**Re: SSD-6698-Mod-2 - Modification 2 Decentralised BESS - Yass Valley (Coppabella) Wind Farm**

Yass Valley Council (YVC) would like to thank the Department of Planning, Housing and Infrastructure for the opportunity to make a submission on proposed Modification 2 to the approved Yass Valley (Coppabella) Wind Farm. Council wishes to formally object to the proposed development on several grounds, as detailed below.

APPENDIX 7
BESS LOCATIONS

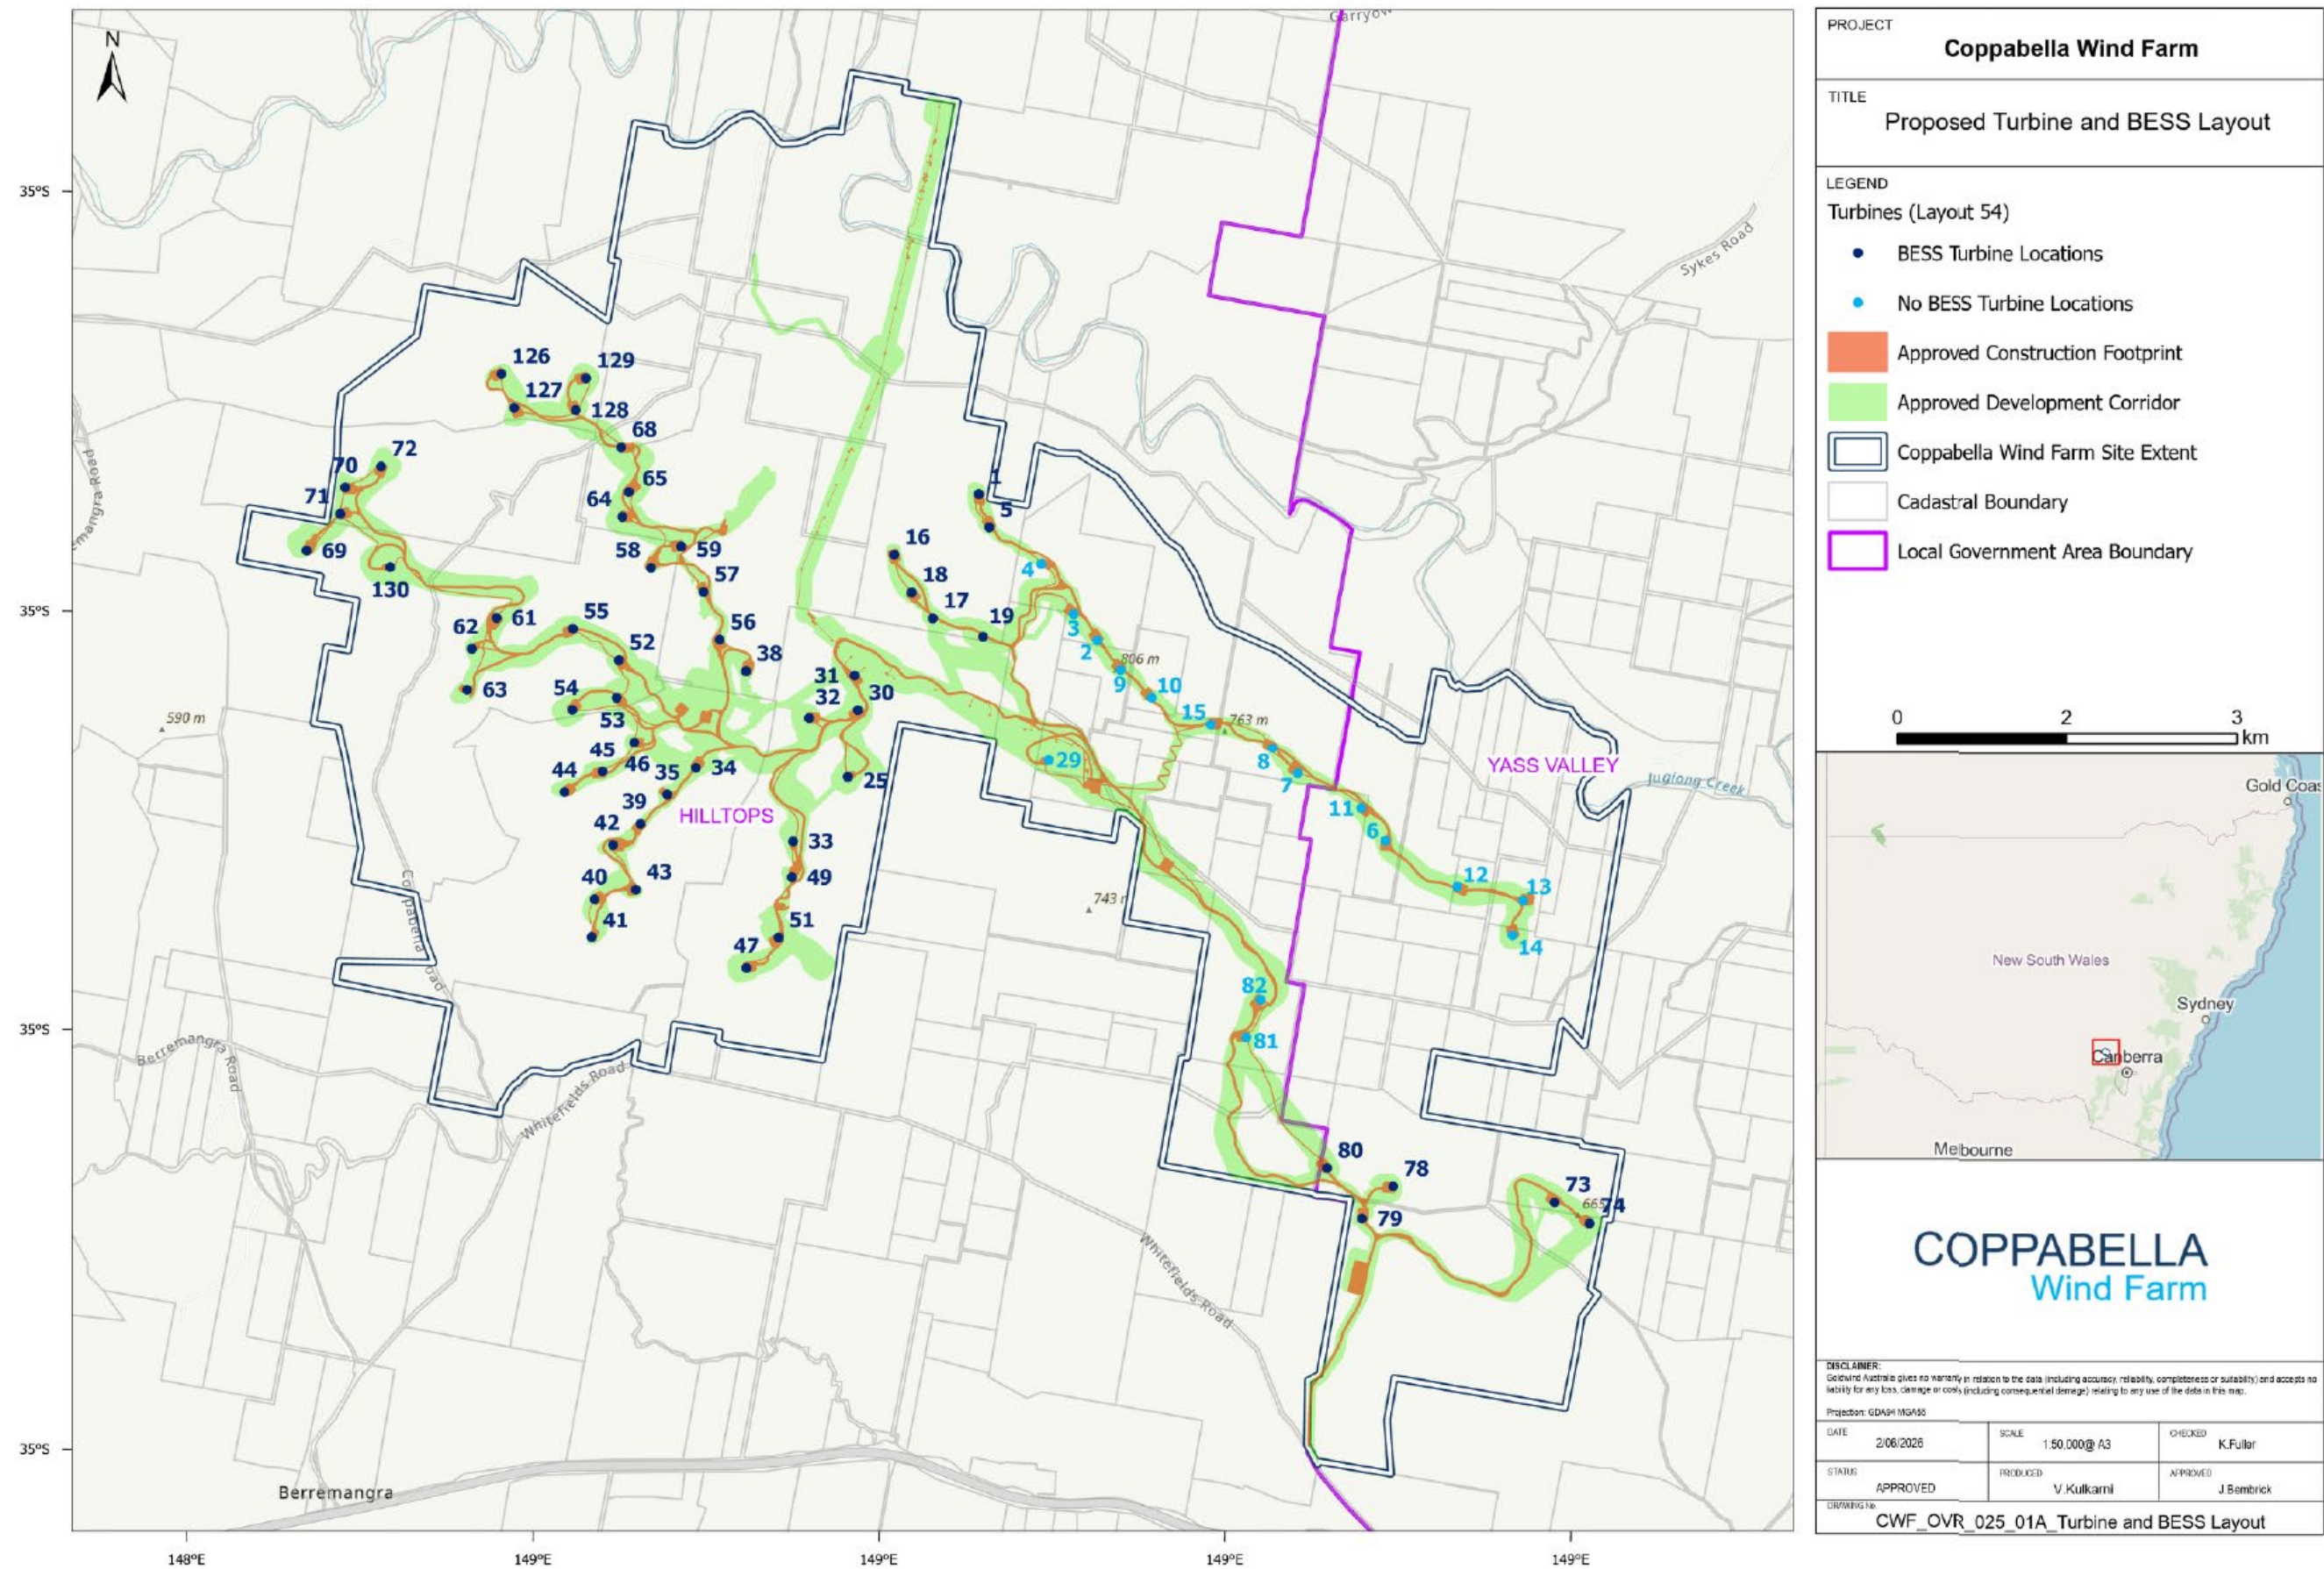
In addition, there is no information within the Modification Application regarding where the BESS systems are to be located across the project area. This means that each individual council impacted by this development is essentially flying blind when trying to ascertain impacts on our residents. If the applicant is unable to pin-point which turbine is suitable for significant energy storage infrastructure, then it is clear that the application has been made prematurely. Impacts on the community cannot be assessed and considered when the applicant is unable, or unwilling, to specify where the development is actually going to be located.

It is incredibly difficult to fully understand how a development can be considered as "substantially the same" when it involves the erection of up to 53 BESS, with no location plan, and no determined location, especially given the substantial additional risk posed by the BESS to fire intensity.

How can the impacts on bushfire risk be properly considered when such basic information is not included in the application? Without determined locations, the application is deficient in identifying, assessing and considering mitigating treatments for each individual BESS.
